RE: RESPONSE TO CITY OF SYDNEY COUNCIL REVISED COMMENTS ON 21ST MAY 2021

SITE ANALYSIS | STREET TREES

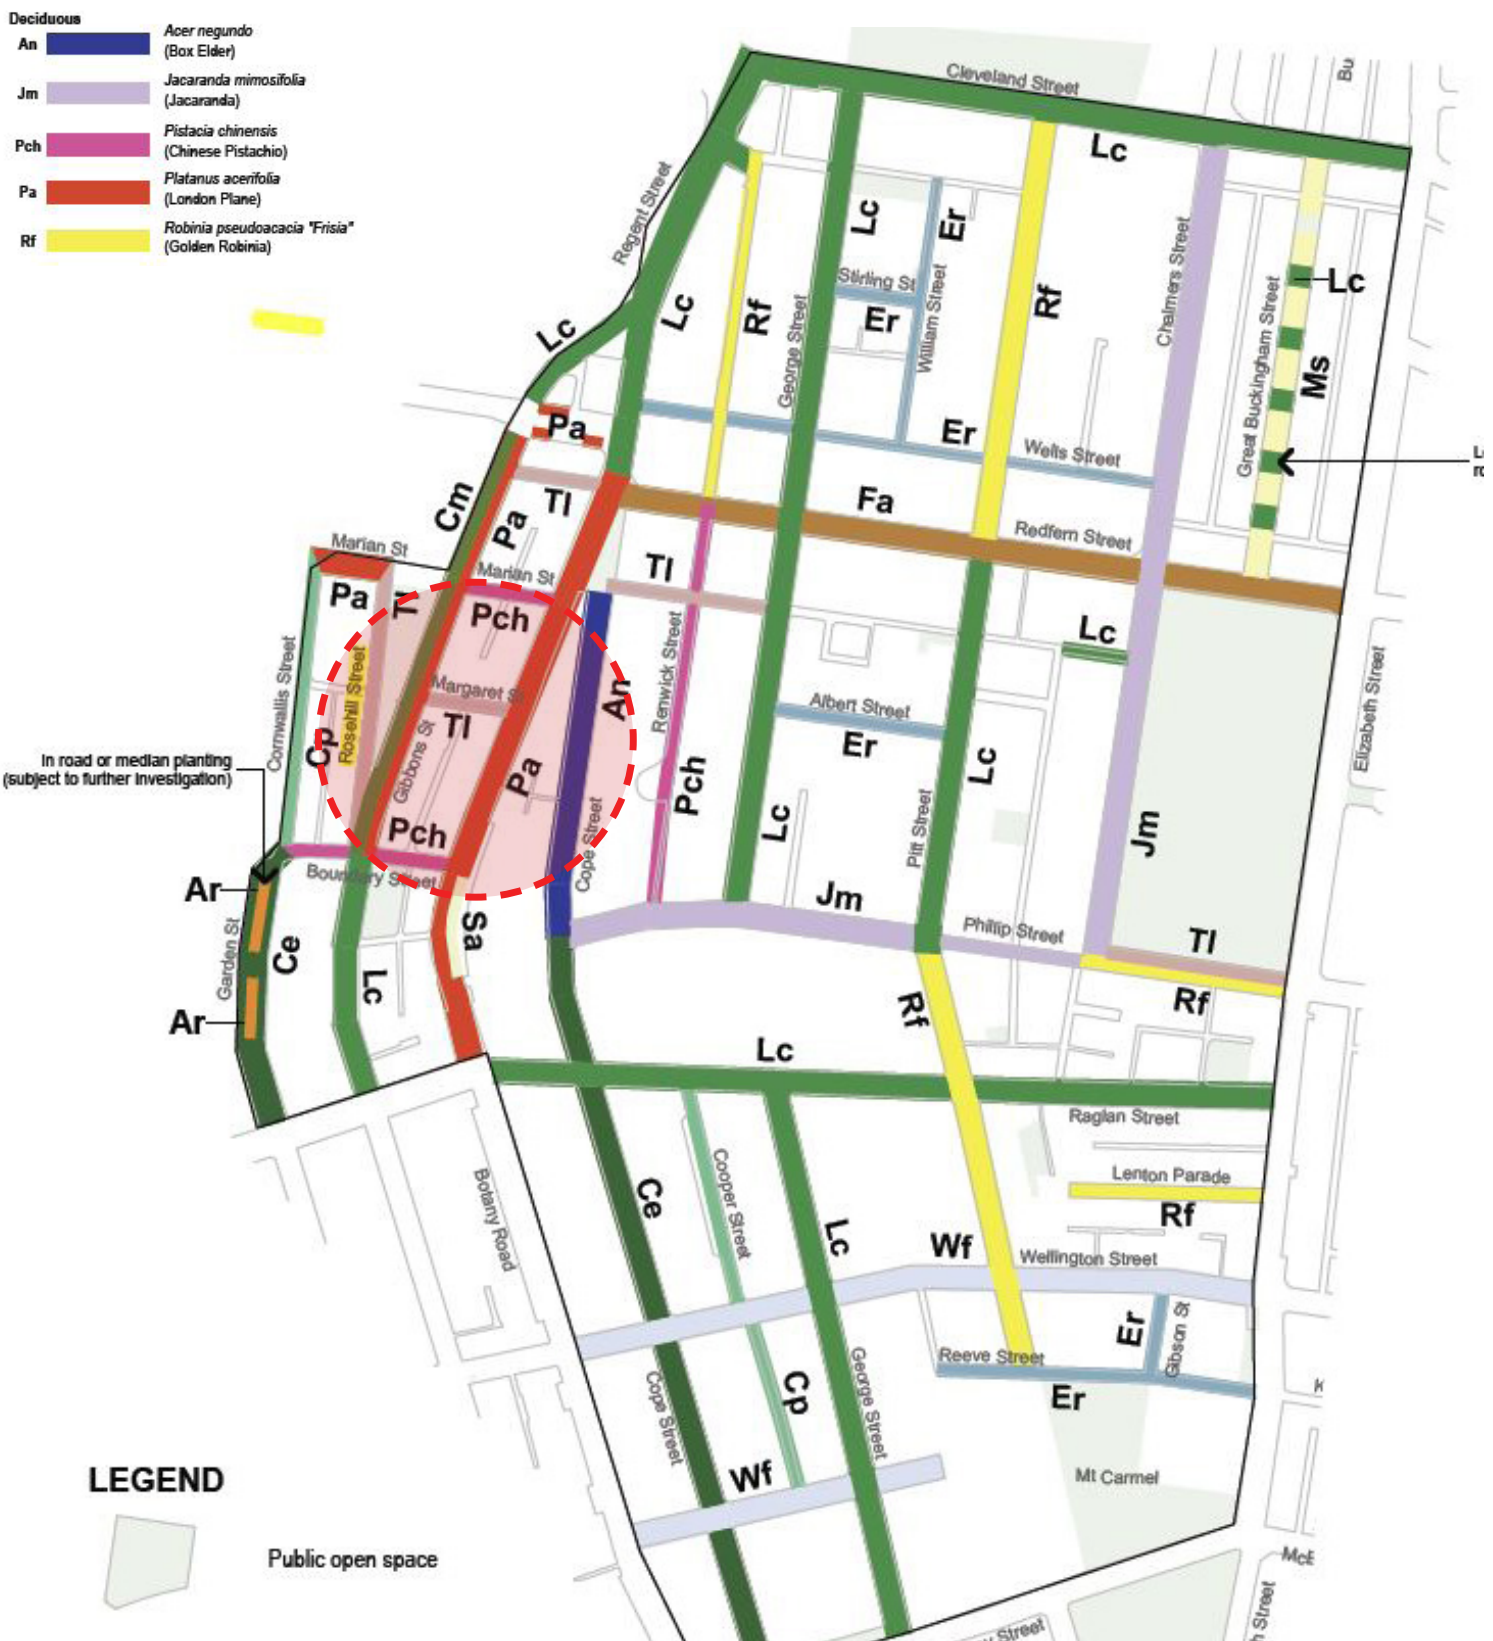
4a - The City does not support the removal of the street trees nos. 2 and 3 (Chinese Pistachio Trees) to facilitate construction access. All plans and documentation must be amended to show retention and protection of these street trees.

Turf support the retention of the two existing Pistacia chinensis trees along Marian St and have reflected these changes in the updated landscape drawing set.

LEVEL 2 | VIEWS - WESTERN TERRACE

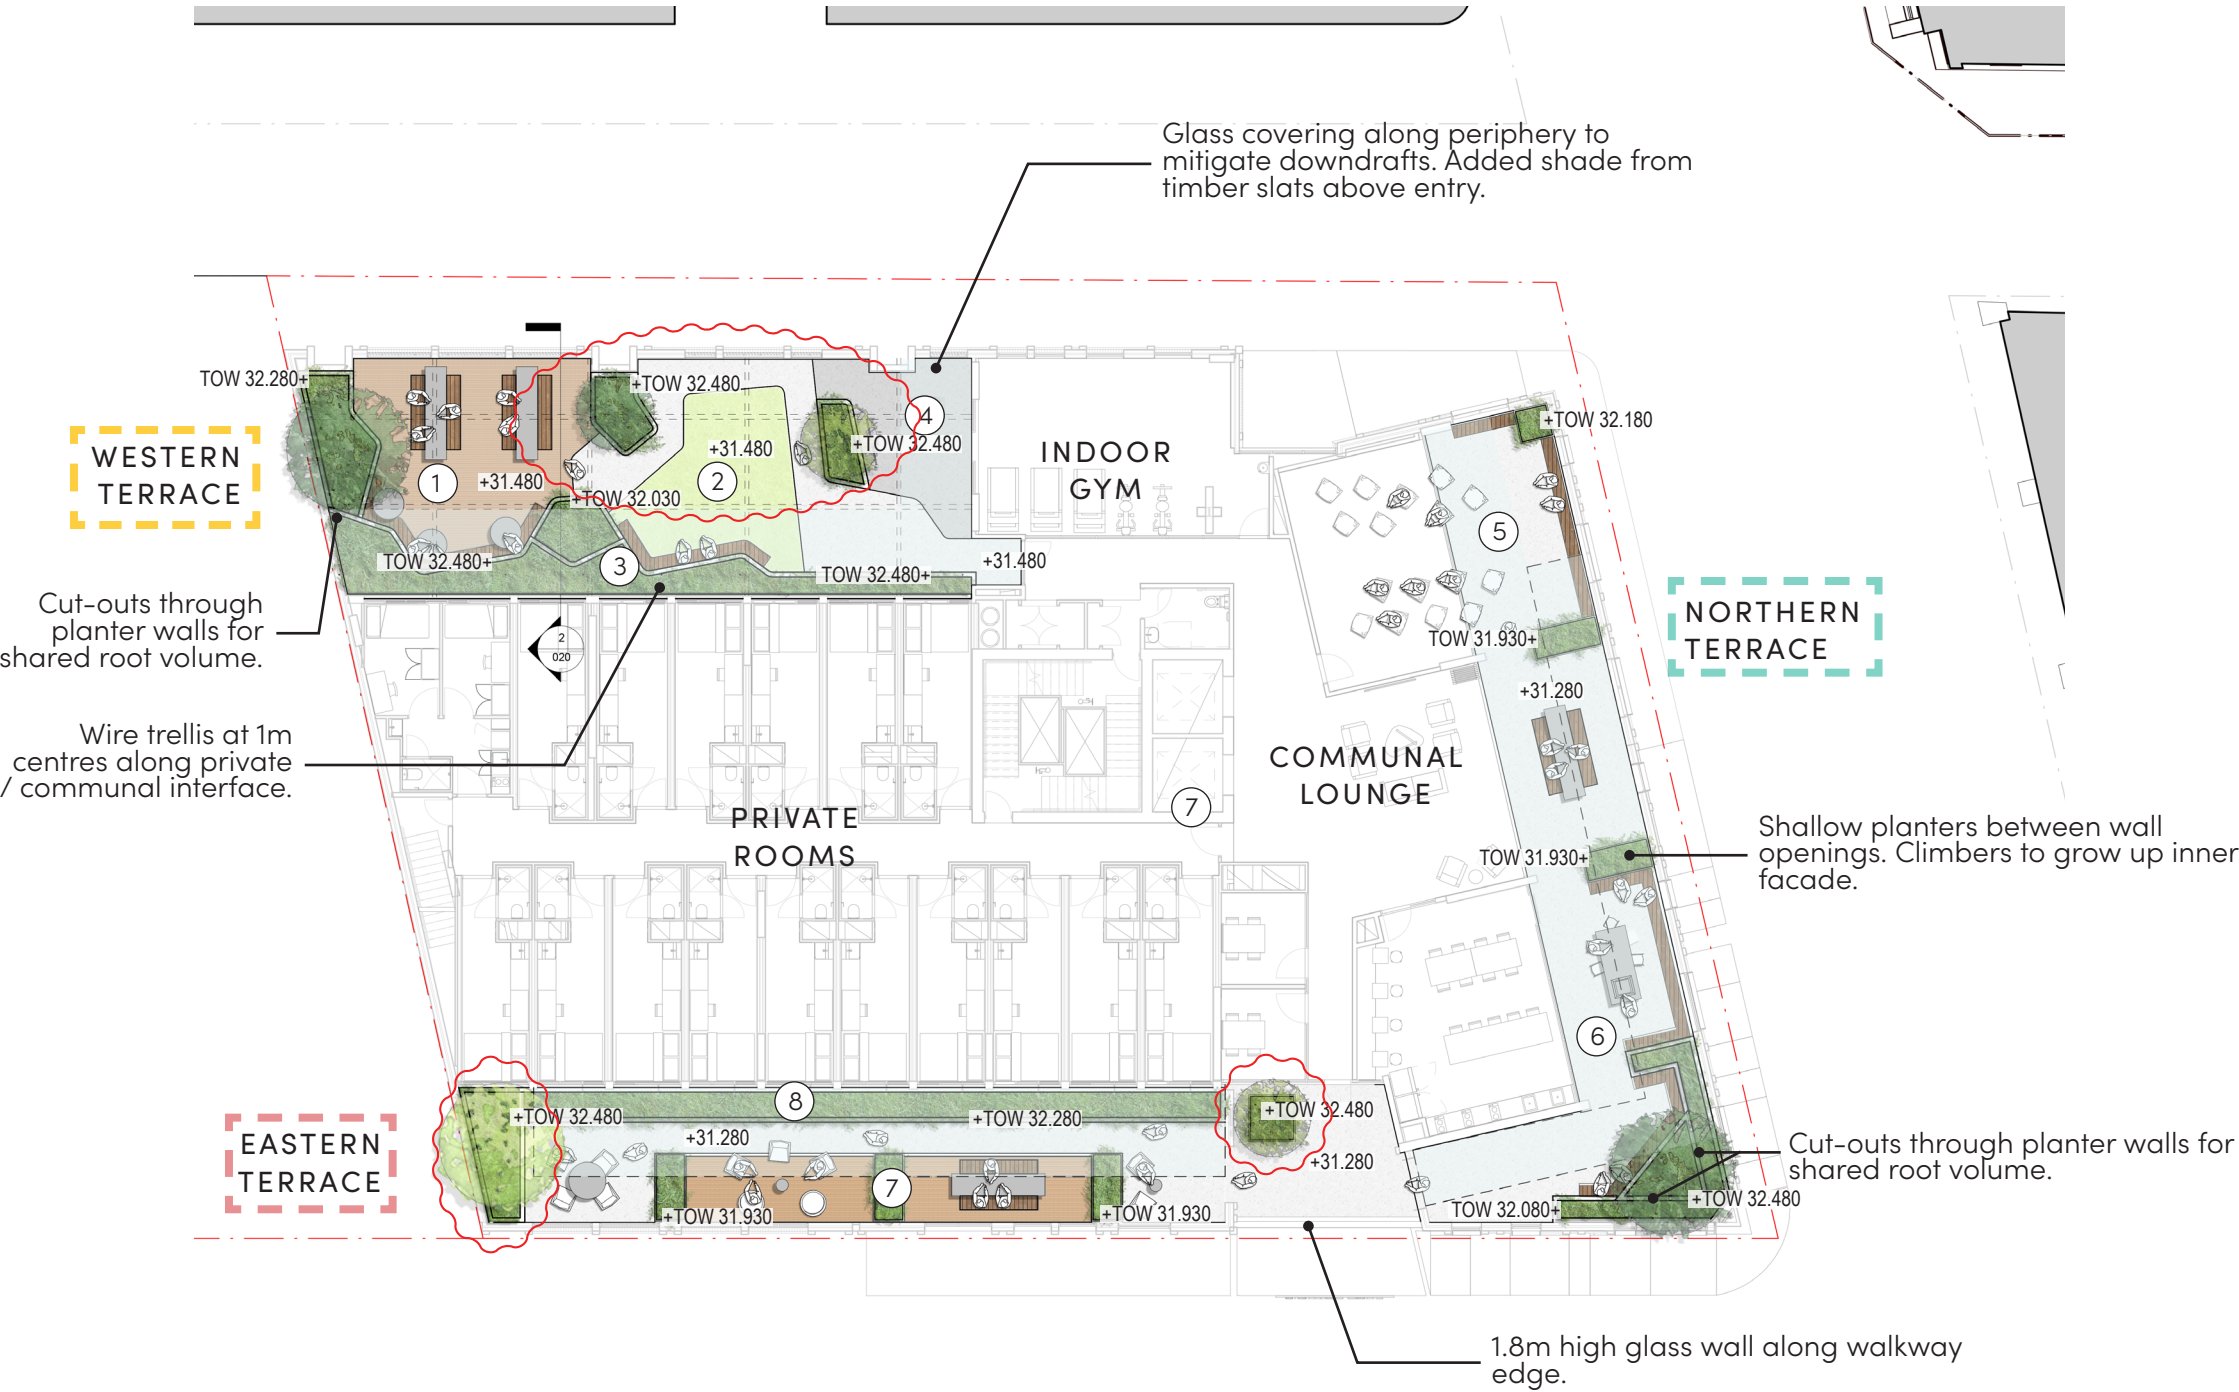
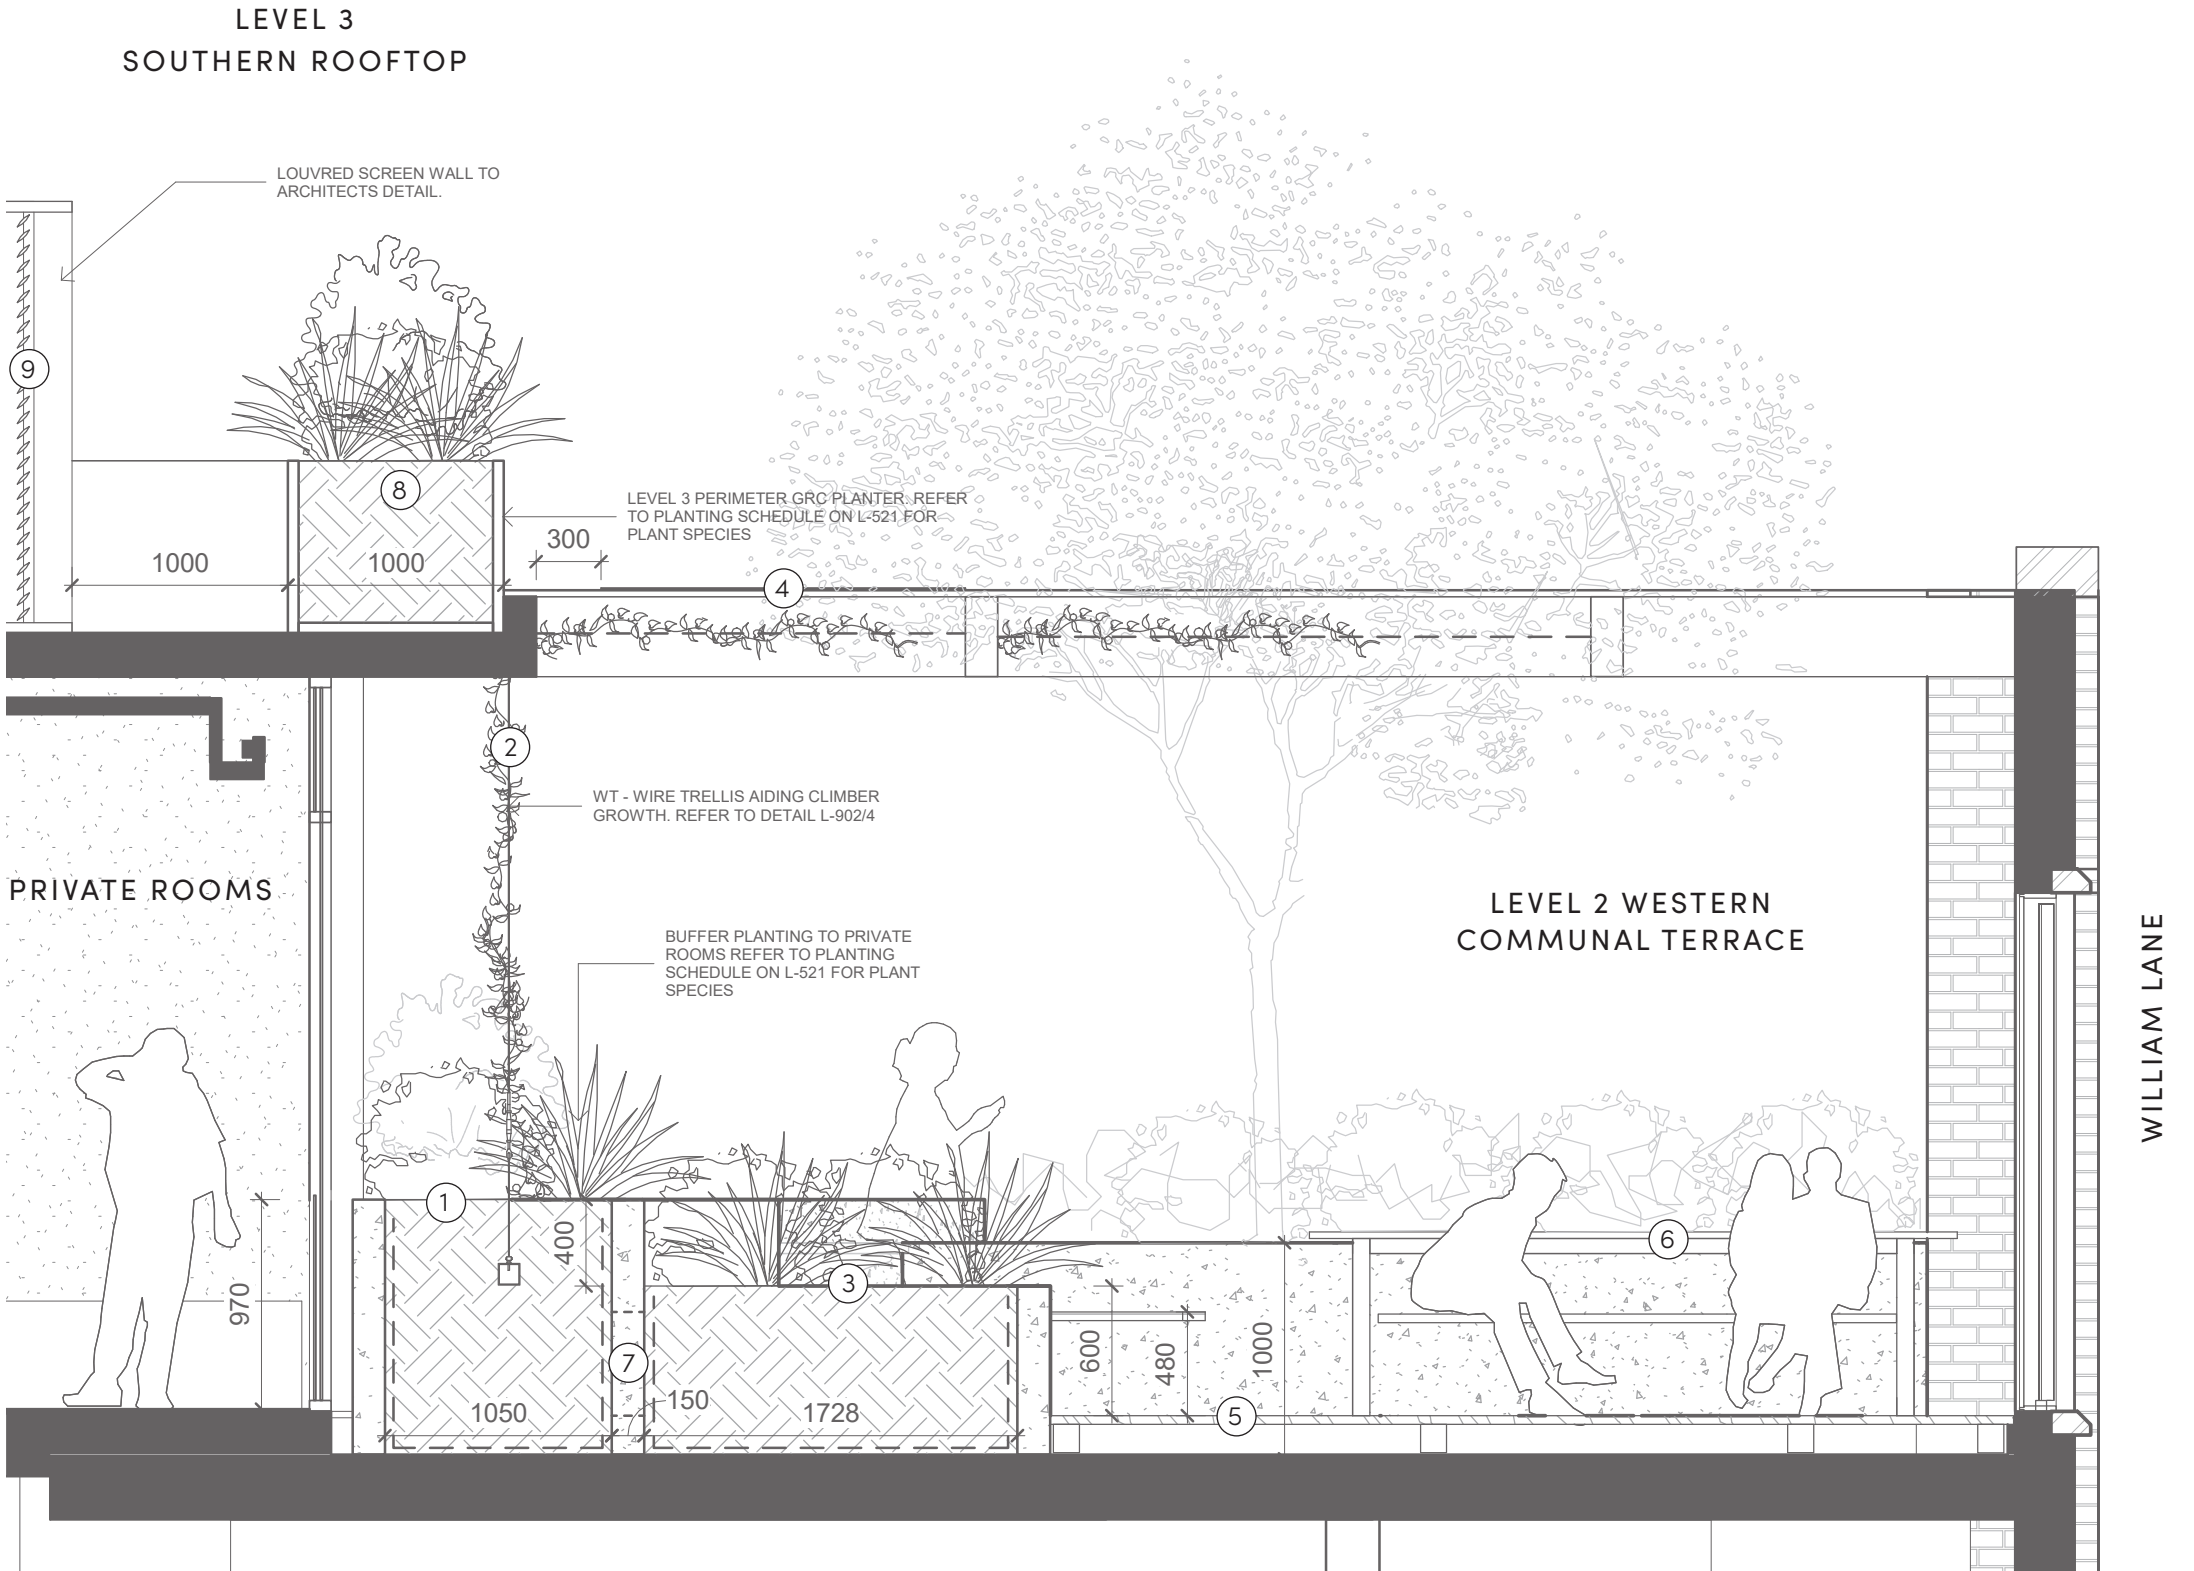
5b- Based on the low-growing species listed in each relevant planter mix (Screening the eastern and western facing dorm rooms) and the lack of detail on fenestration and screening in this location, this remains unconfirmed.

On the eastern terrace interface, mid-level screening will be provided by some species in the mix, in particular Cordyline stricta & Blechnum 'silver lady' (when mature). Supplementary screening has been provided by including Cordyline glauca in planting mix 5 also. On the western terrace interface, climbing species following vertical wires at 0.5m centres are proposed in addition to the low growing species mentioned. Additional mid-level shrub planting is proposed to supplement the currently proposed plants and increase screening. Cordyline stricta & glauca have been added to mix 2. These changes have been reflected in the updated drawing set.
